City of Albuquerque Stormwater Construction Site Inspection Report

ESC File No.	B18E029	Project Name:	The Peaks by Markana Ph 2		
NPDES Id. No.	NMR1004QW	Location:	6500 Glendale Avenue NE		
11/15/2023	Owner	Contractor			
Operator	KLA 9, LLC.	Kasam Construction			
Contact name & title	Faizel Kassam	Stephen Pendergraft			
e-mail	fkassam@legacy-hospitality.com	Spendergraft@Legacydm.net			
Contact Phone #	505-489-4474	720-7188			
COA Inspector	Doug Hughes	Start/End Time:	10:30am		
Construction Phase:	Staging				
Type of Inspection:	Regular	Storm Event	Past Storm Event >0.25"	311/Complaint	Follow Up
Weather at time of inspection?		Cloudy	Temperature:	~	55
Estimated date of last storm 0.25" or greater		8/8/2023

0

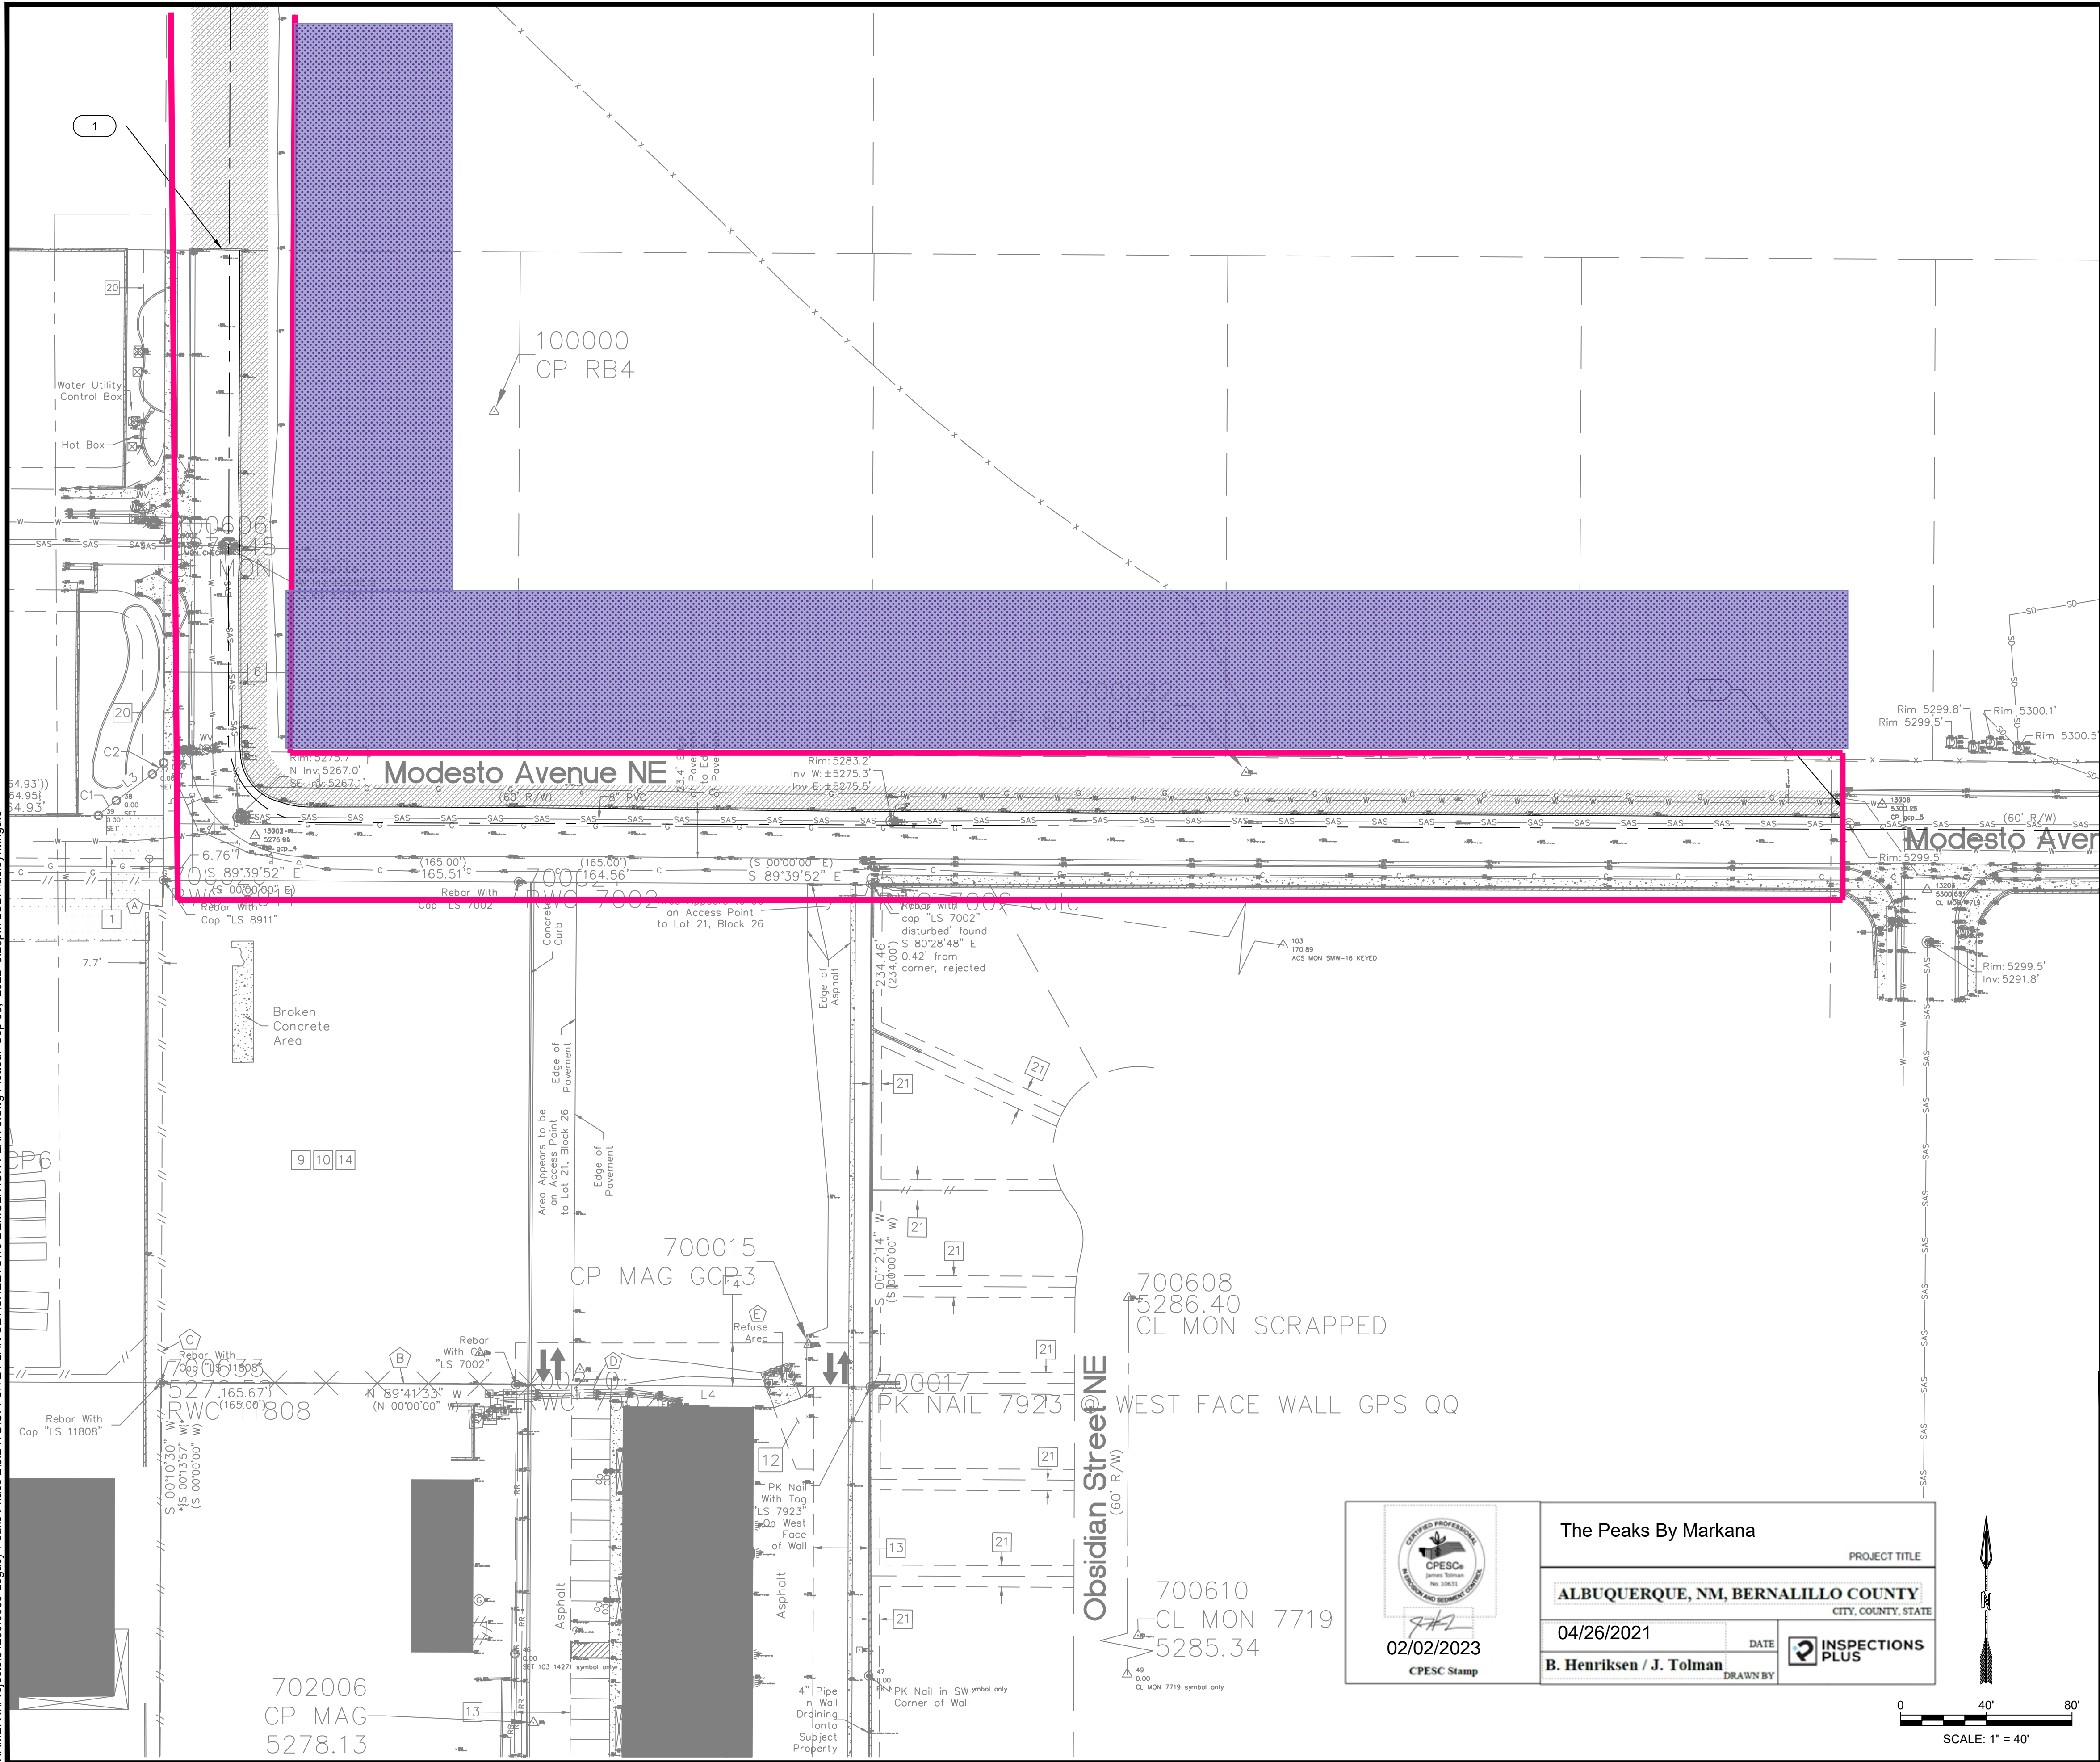
Item Number	Deficiency/ Corrective Action				
1	SWPPP - The offsite areas were added to the SWPPP map, but specifications for perimeter controls and stabilization were still missing on the offsite 40' to 50' wide strip of land disturbing activities located north of Modesto Ave and east of Glendale Ave on the Pueblo of Sandia's property in violation of CGP 2.2.3 and CGP 2.2.14 respectively. Self-inspections were not performed during the 497 days from 6/29/22 to 11/8/23. At least 35 inspections were missed at a rate of one inspection every two weeks, not counting any missed rain event inspections. Required Mitigation: Add controls to the SWPPP map.				
2	BMPs - Perimeter controls and stabilization are still missing on the offsite 40' to 50' wide strip of land disturbing activities located north of Modesto Ave and east of Glendale Ave on the Pueblo of Sandia's property in violation of CGP 2.2.3 and CGP 2.2.14 respectively. Construction Exits(CE) had been reset onsite, but they didn't extend through the ROW to the paved city street. Required Mitigation: Add the missing BMPs.
